Recommendation Report for Planning Permission for Works or Extension to a Dwelling

REF NO: BN/10/21/HH

LOCATION: 2 Park Cottages
Goodacres
Barnham
PO22 0JE

PROPOSAL: Loft conversion consisting of hip-to-gable roof extension and rear box dormer with roof windows to front elevation.

Drawing  
**Proposed Plans**

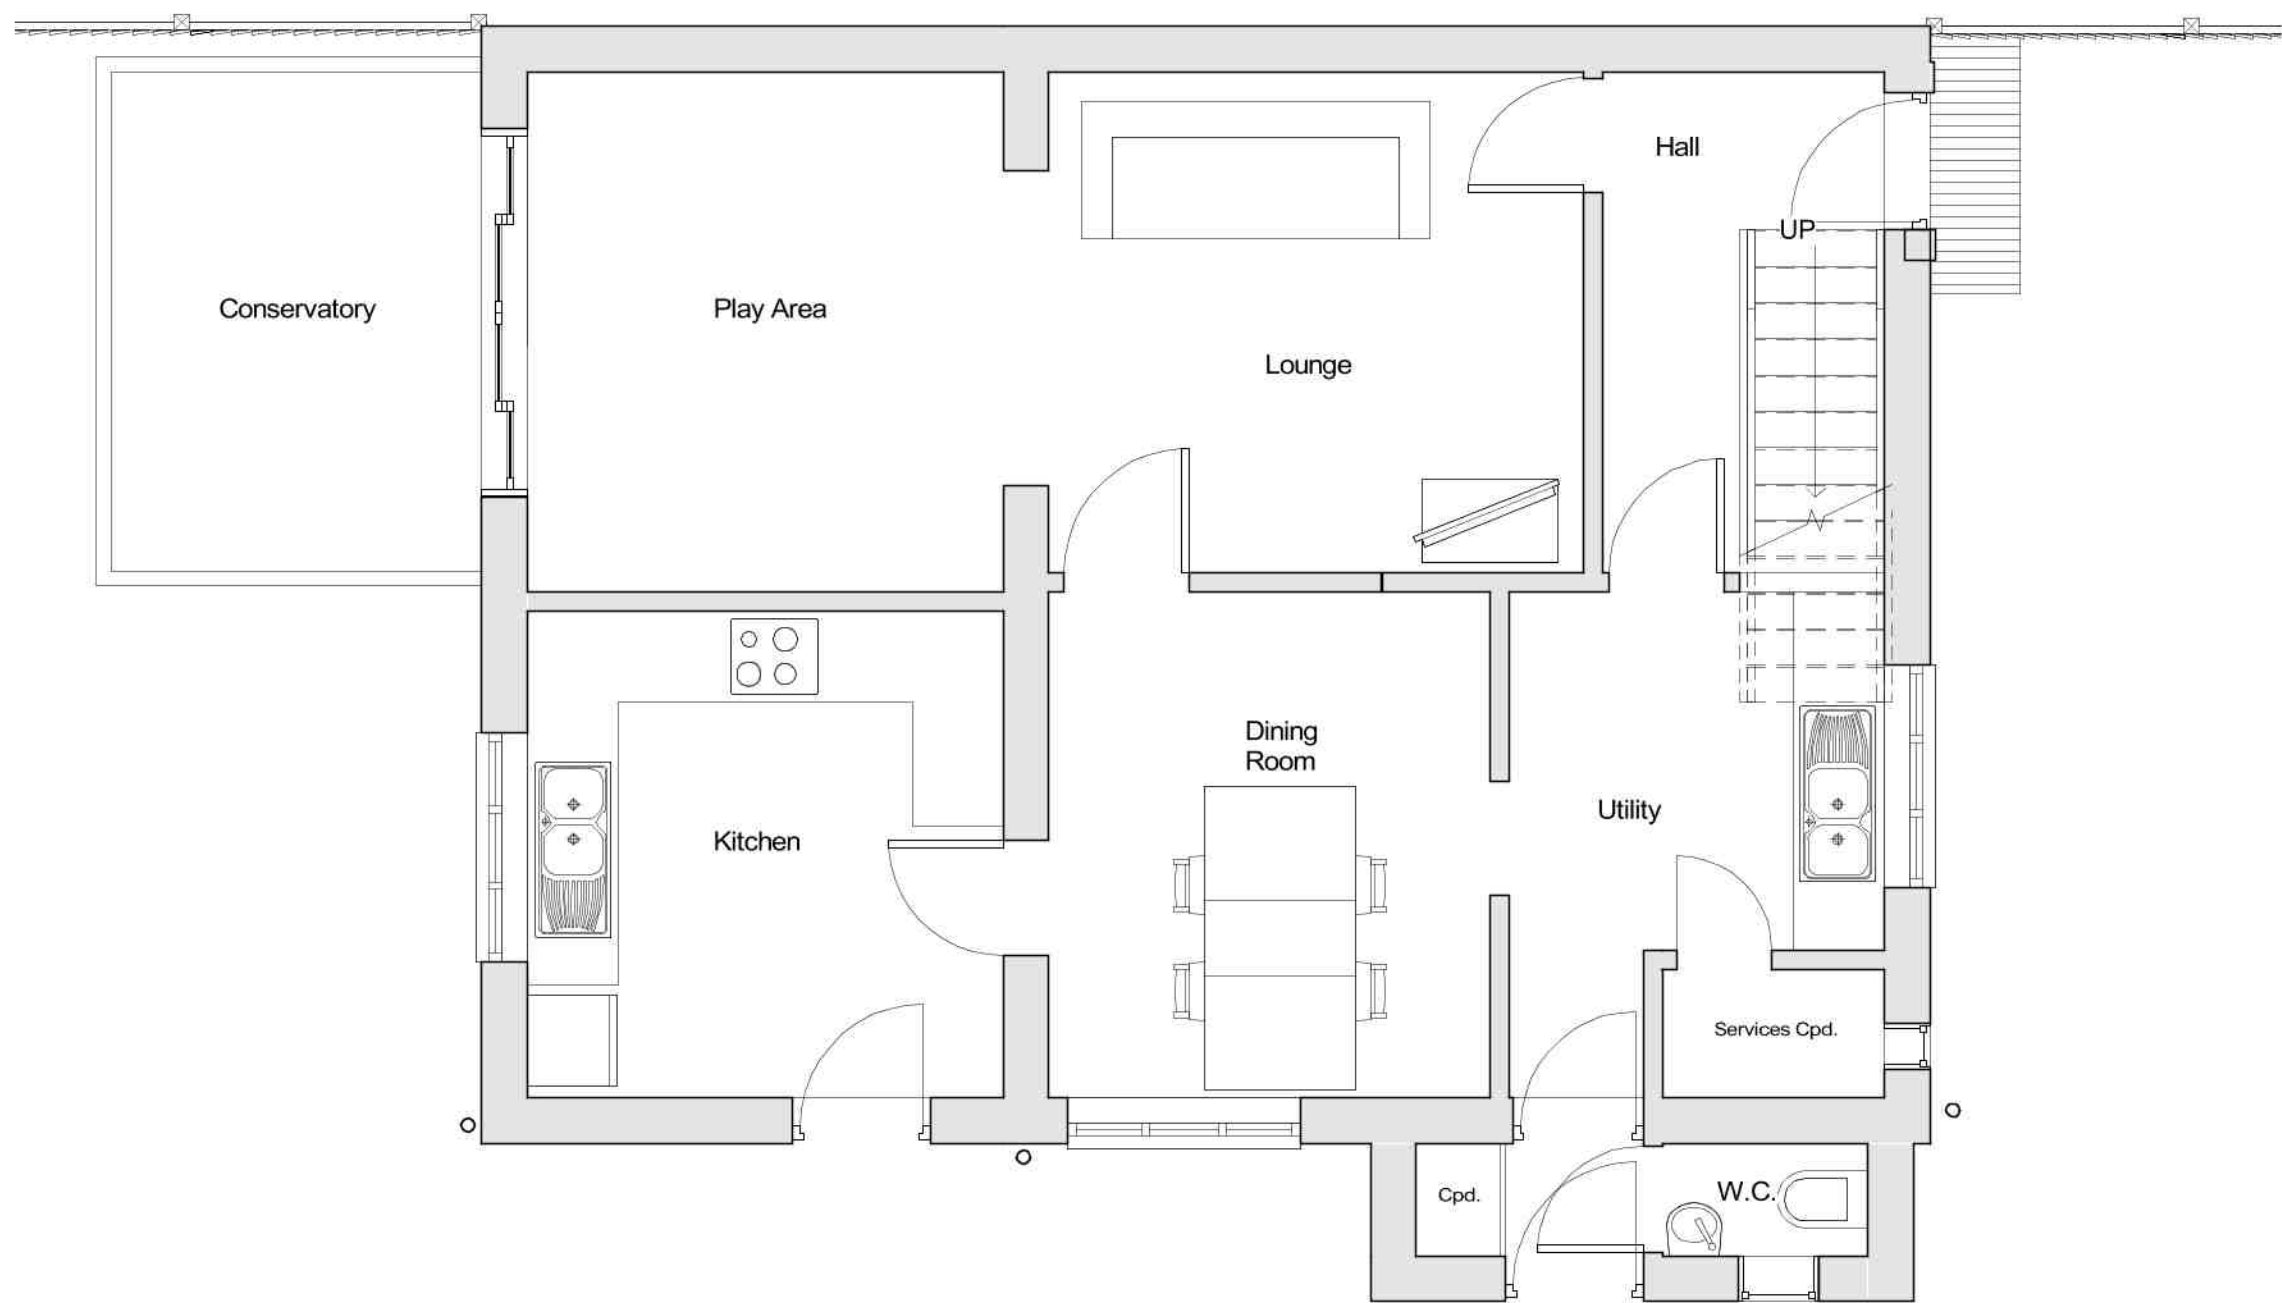
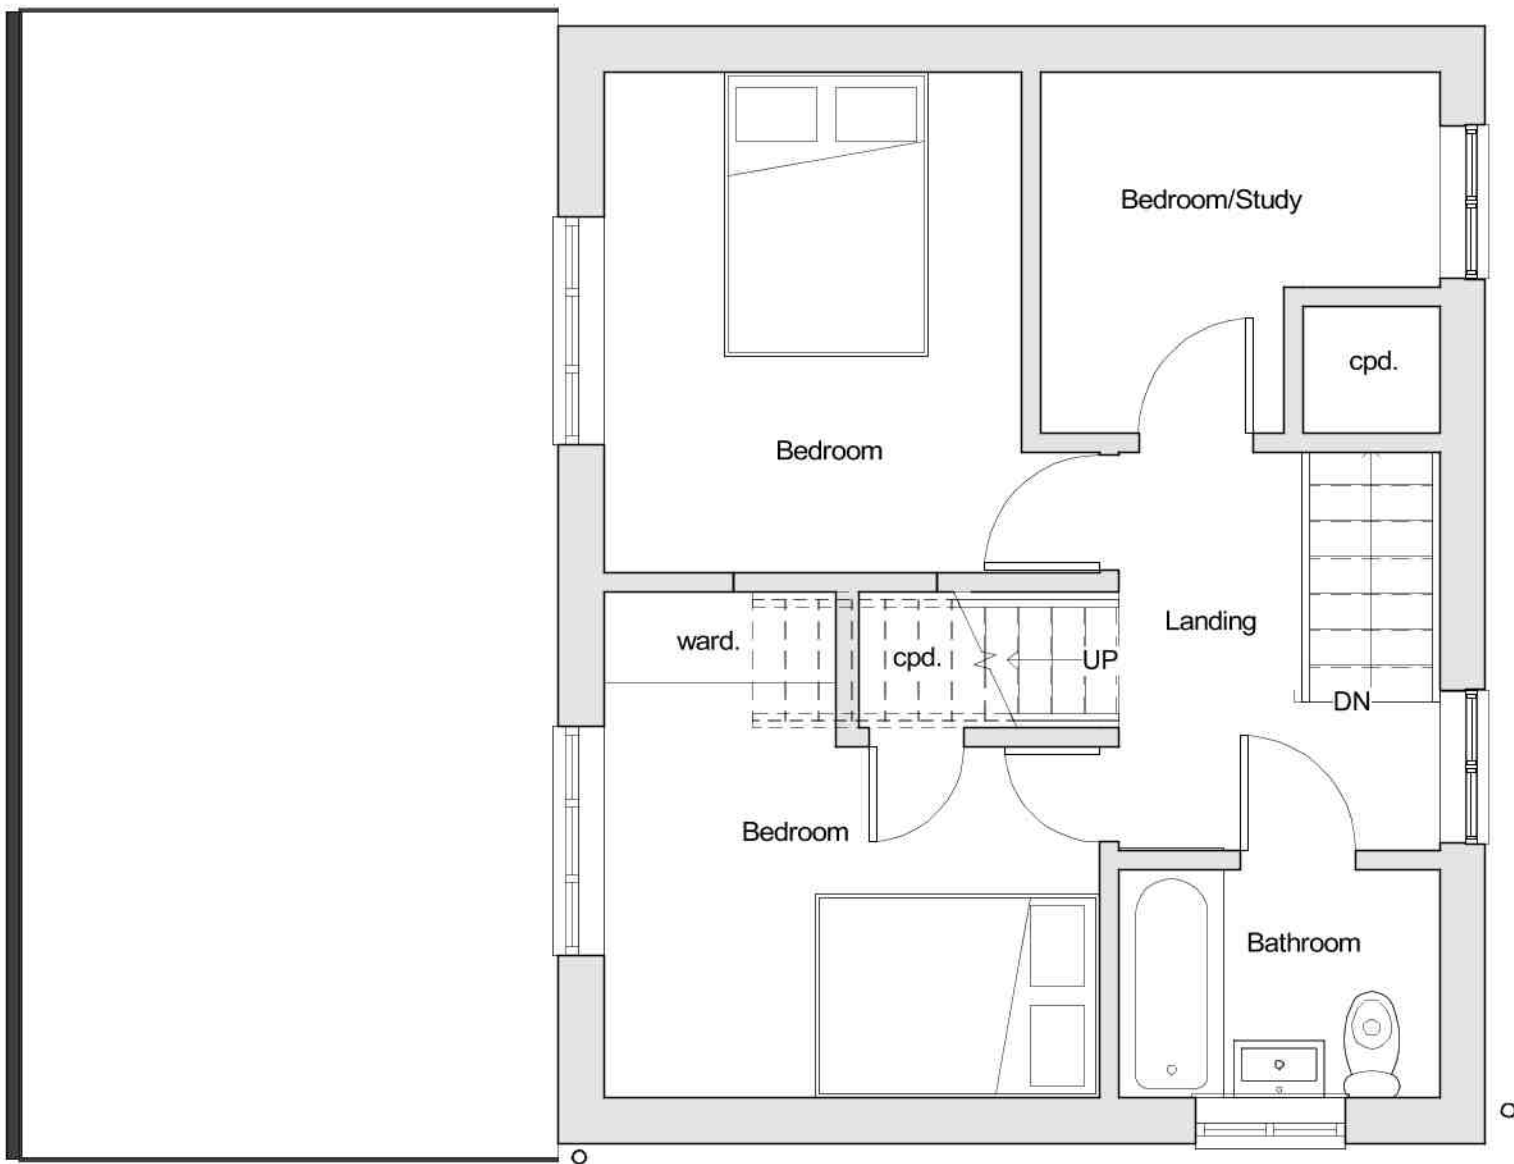
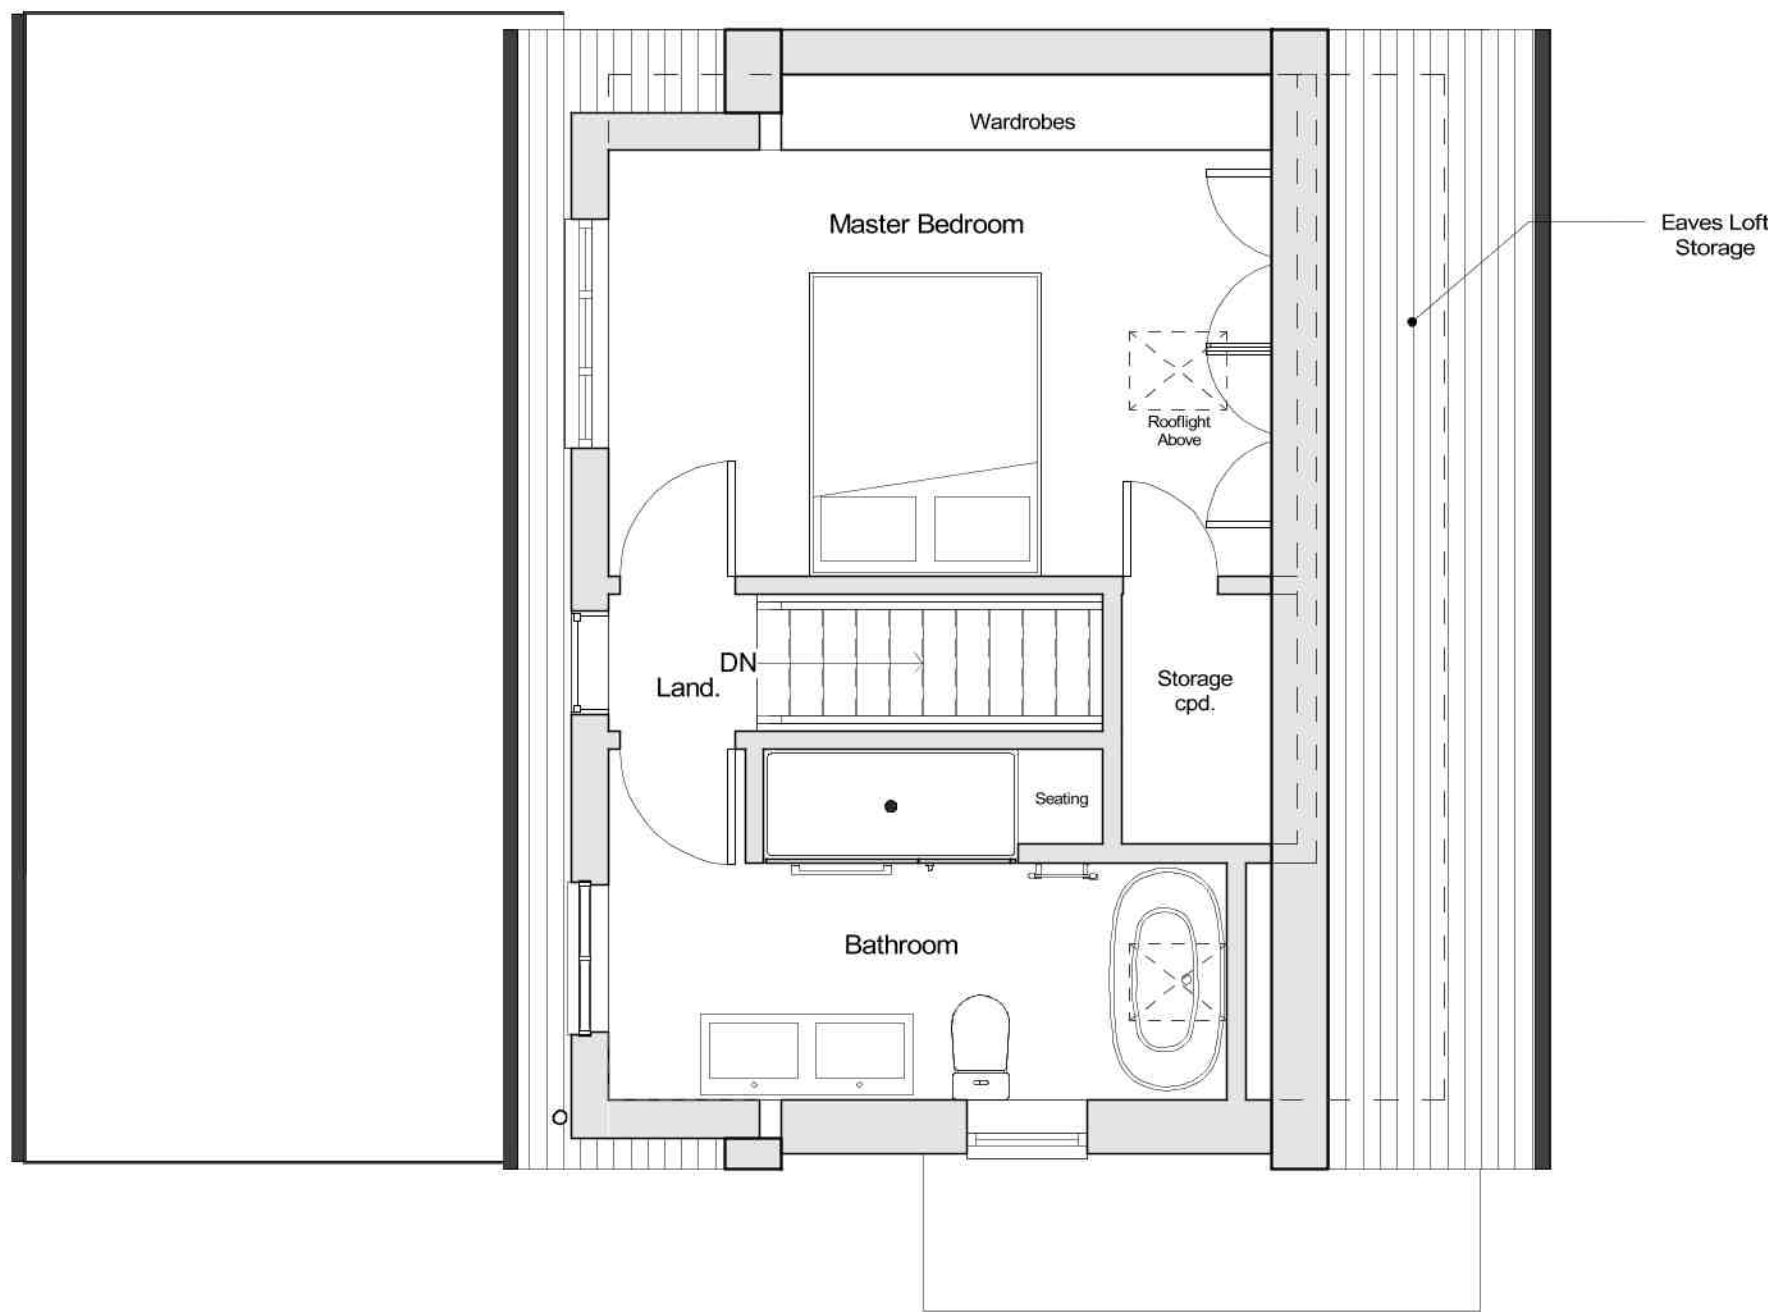
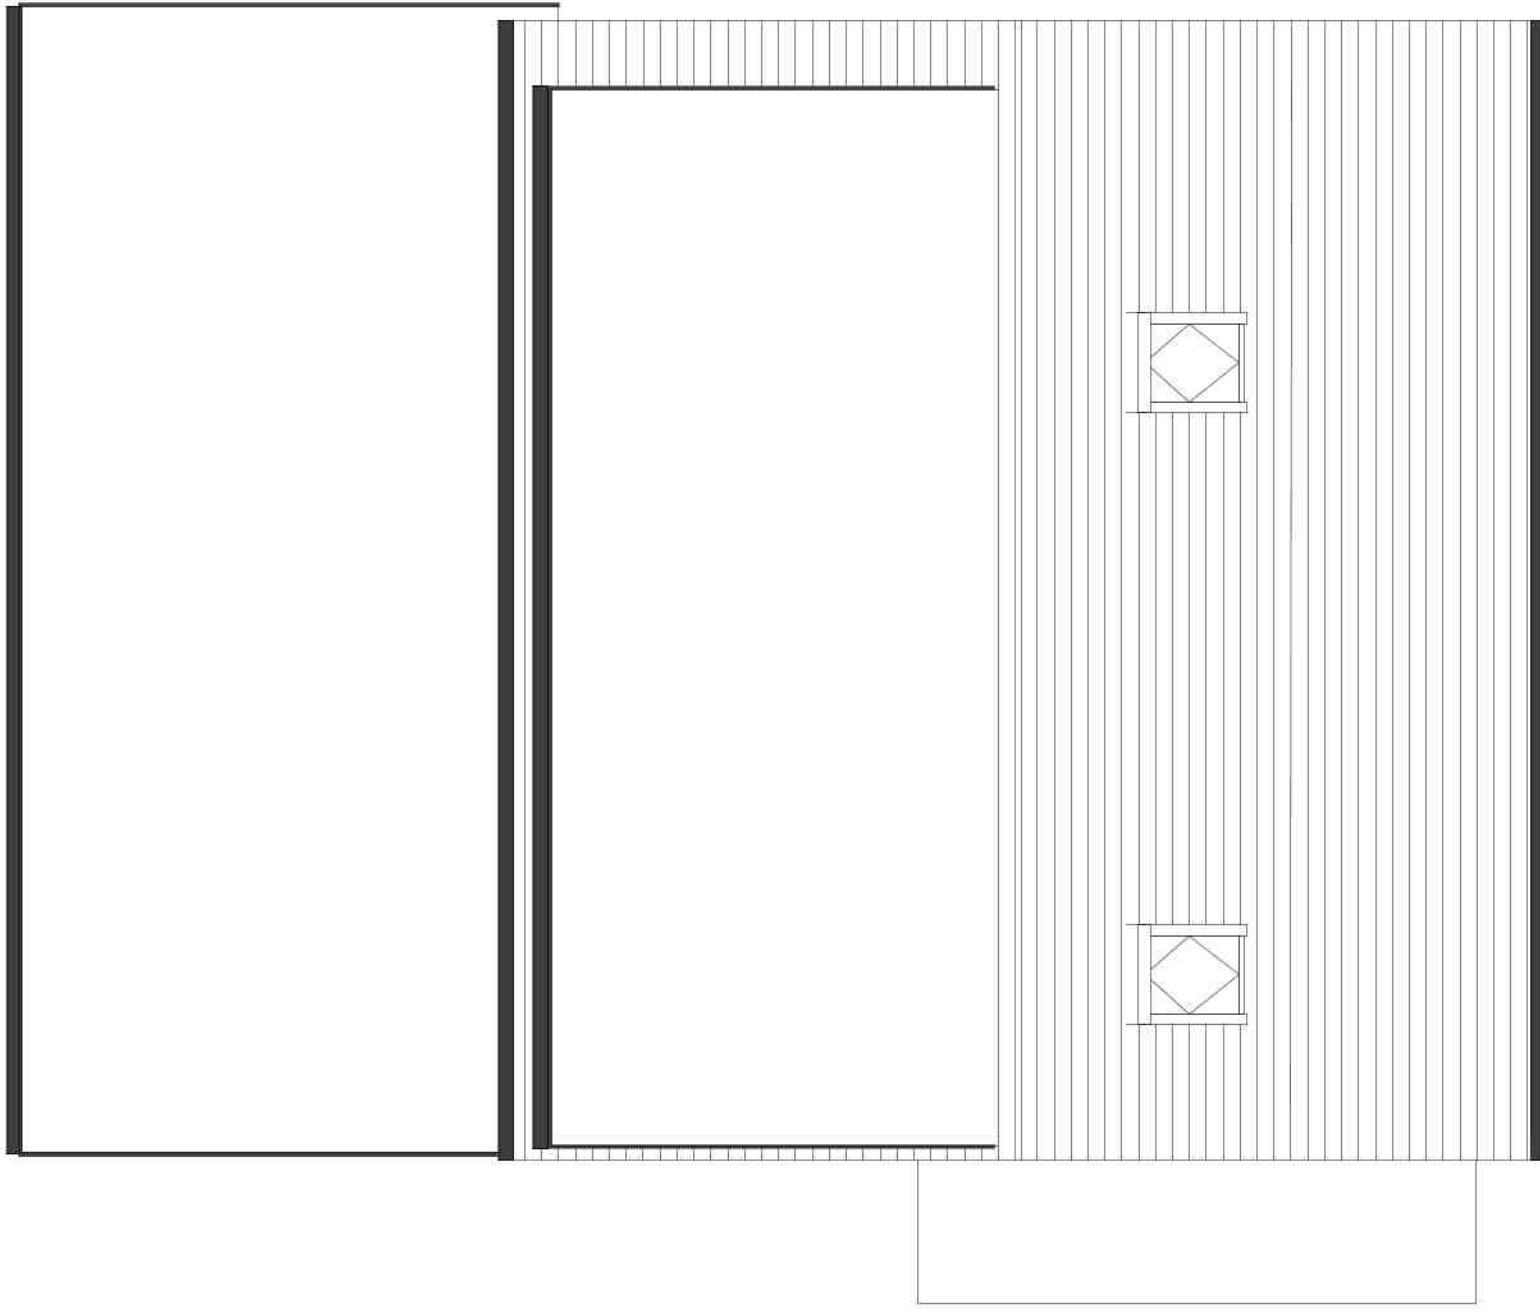
The extension appears to have been sympathetically designed to be constructed from materials which relate well to those currently in use on the host dwelling. Having regard to scale the extension, the existing eaves line it to be retained and the flat roof of the box dormer will be under that of the existing ridge line. The scale of the space to be provided is thought to be appropriate for its intended use and is seen as an effective use of the site under Arun Design Guidance. The fenestration is of a suitable scale and design to be in keeping with the host dwelling.
